Condition 6 (ecological enhancements) reads:

The development shall be undertaken in **strict accordance with the recommendation outlined in under Section 6 of the Windrush Ecology Report** (Land adjacent to Cotefield House, Bodicote). No development shall commence above slab unless and until **full details of the ecological enhancements outlined in Section 6 of the Windrush Ecology Report (Land adjacent to Cotefield House, Bodicote) have been submitted and approved in writing by the local planning authority**. The enhancements shall thereafter be provided prior to the first occupation of any dwelling.

Drawing No. A-030-COND 6&11 & 13&14 and 5 Date MARCH 2023

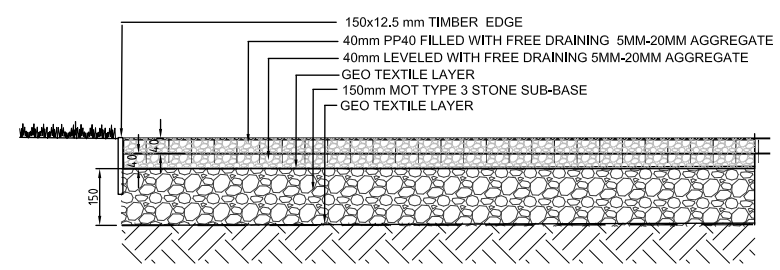
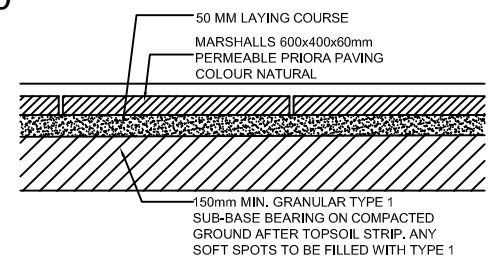
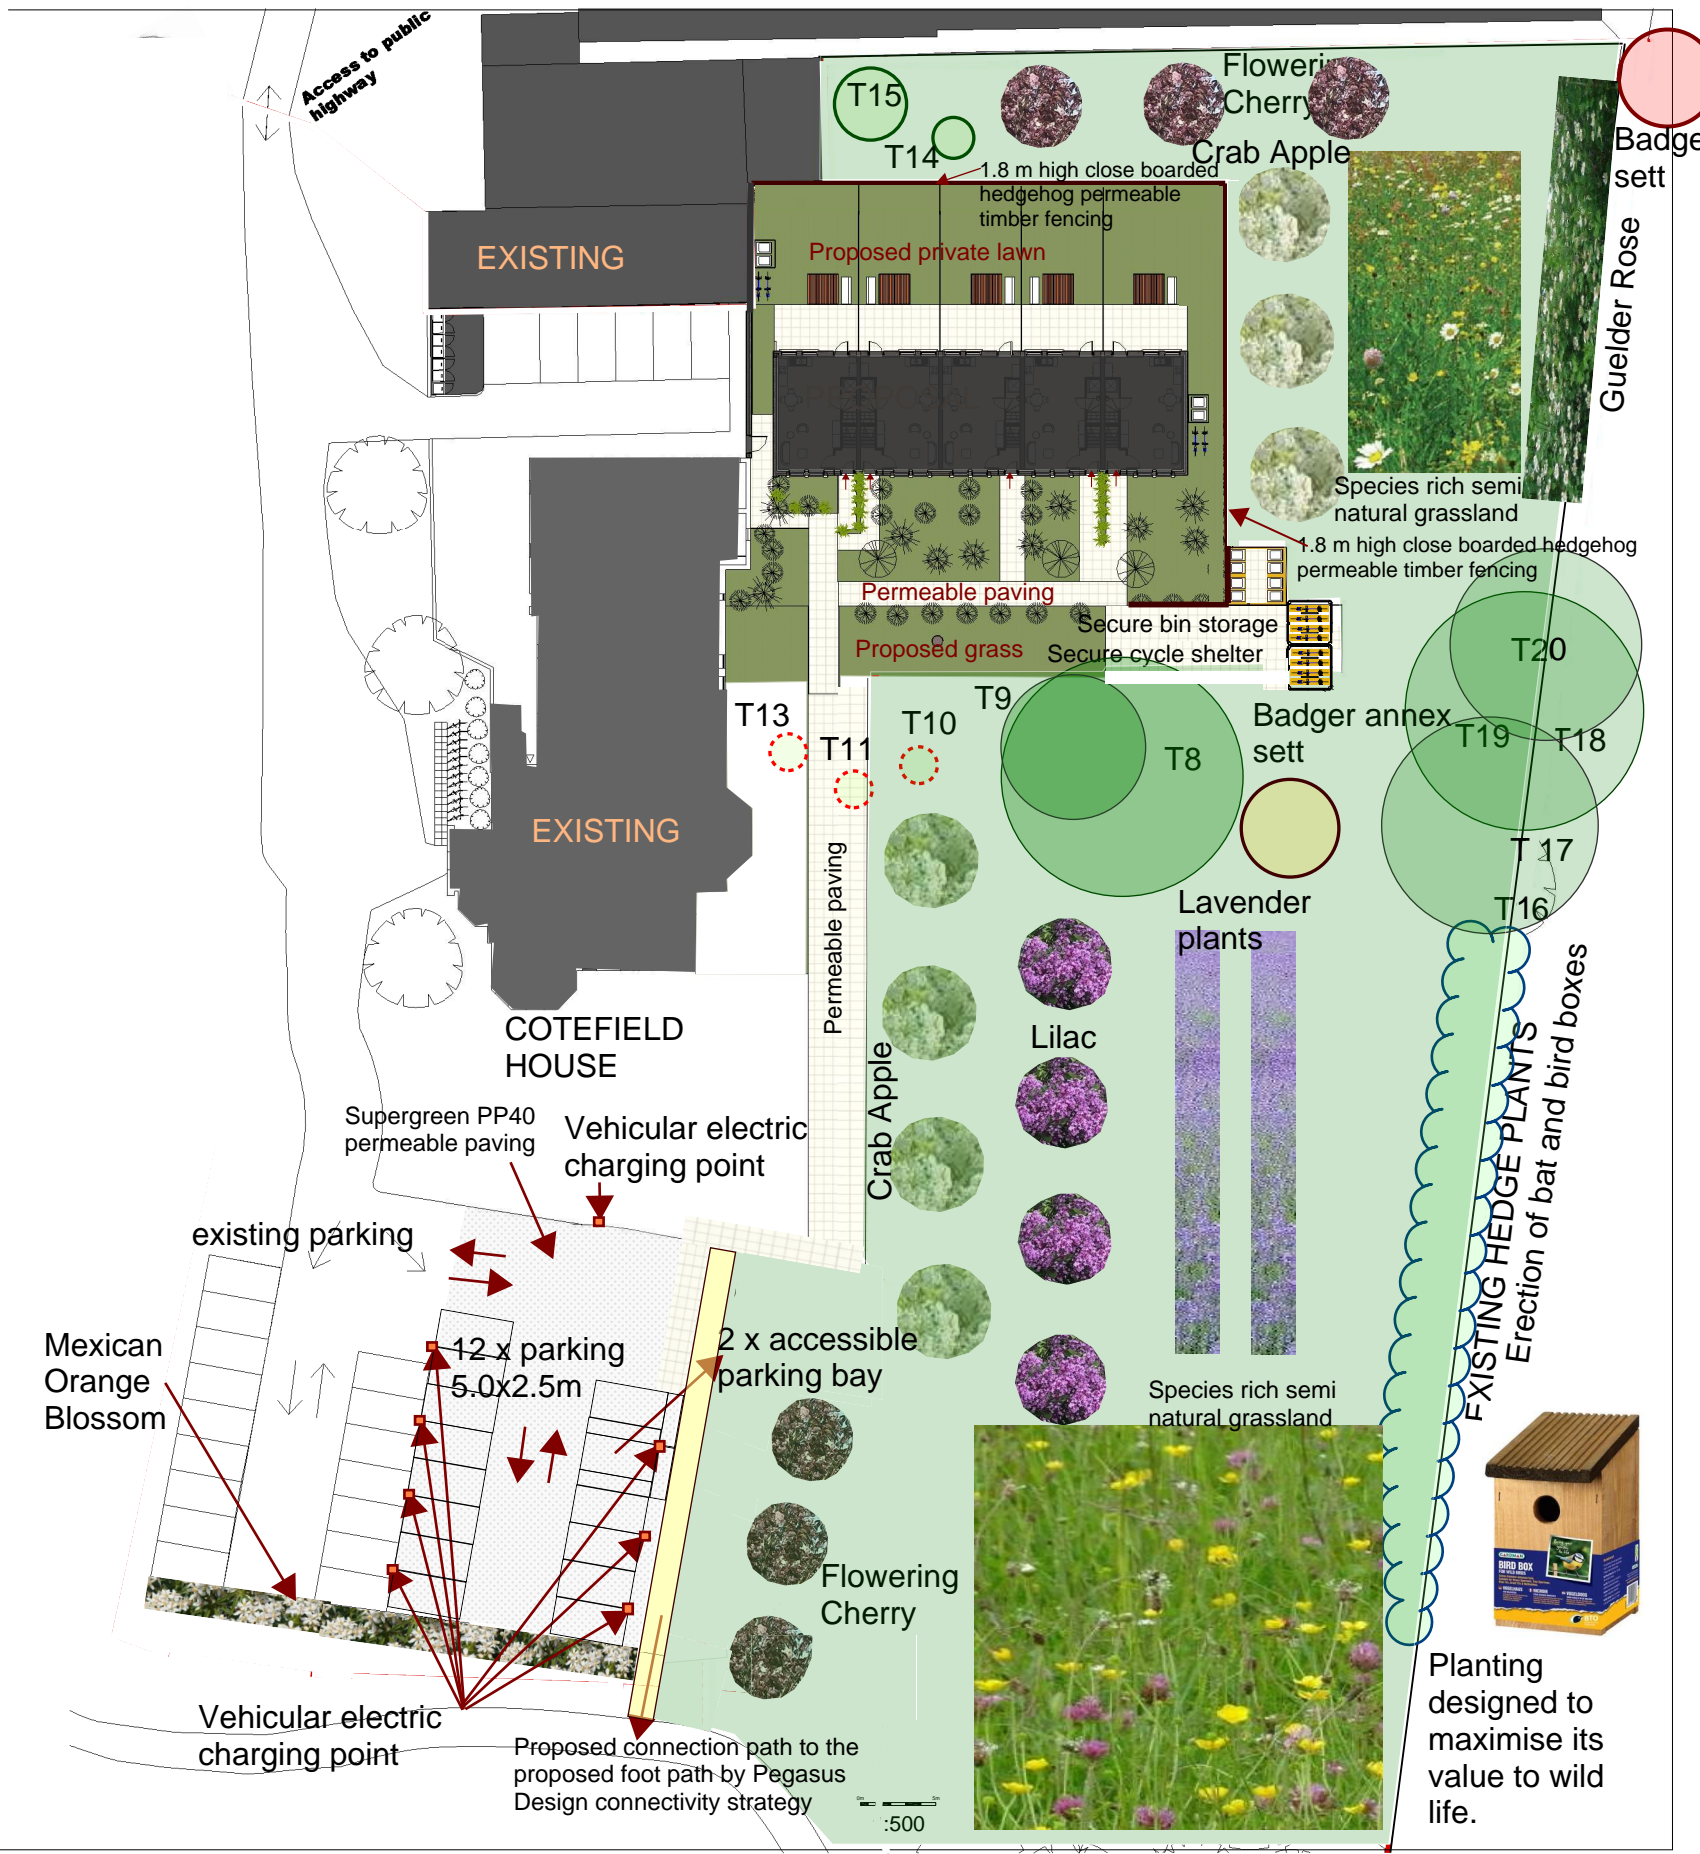
The plan also includes some details of the enhancements provided for wildlife. However, I can't find details about the location, number or type of bird/bat boxes being installed. There are also minimal details about the management of habitats for wildlife (recommended in section 6.2 of the Windrush ecology report).

There are no details about badger mitigation, and I can't find any details on the lighting (this should be submitted to show that the lighting accords with BCT guidance note 08/23).

Condition 11 requires that details (species, number, sizes, and positions) of the tree and shrub planting, along with details of the grass seeded/turfed areas are provided. The landscaping plan shows this information. I would expect there to be more information about management of these habitats (again, in line with the Windrush Ecology report) including a planting schedule and management and monitoring plan to ensure the habitats are created and maintained appropriately.
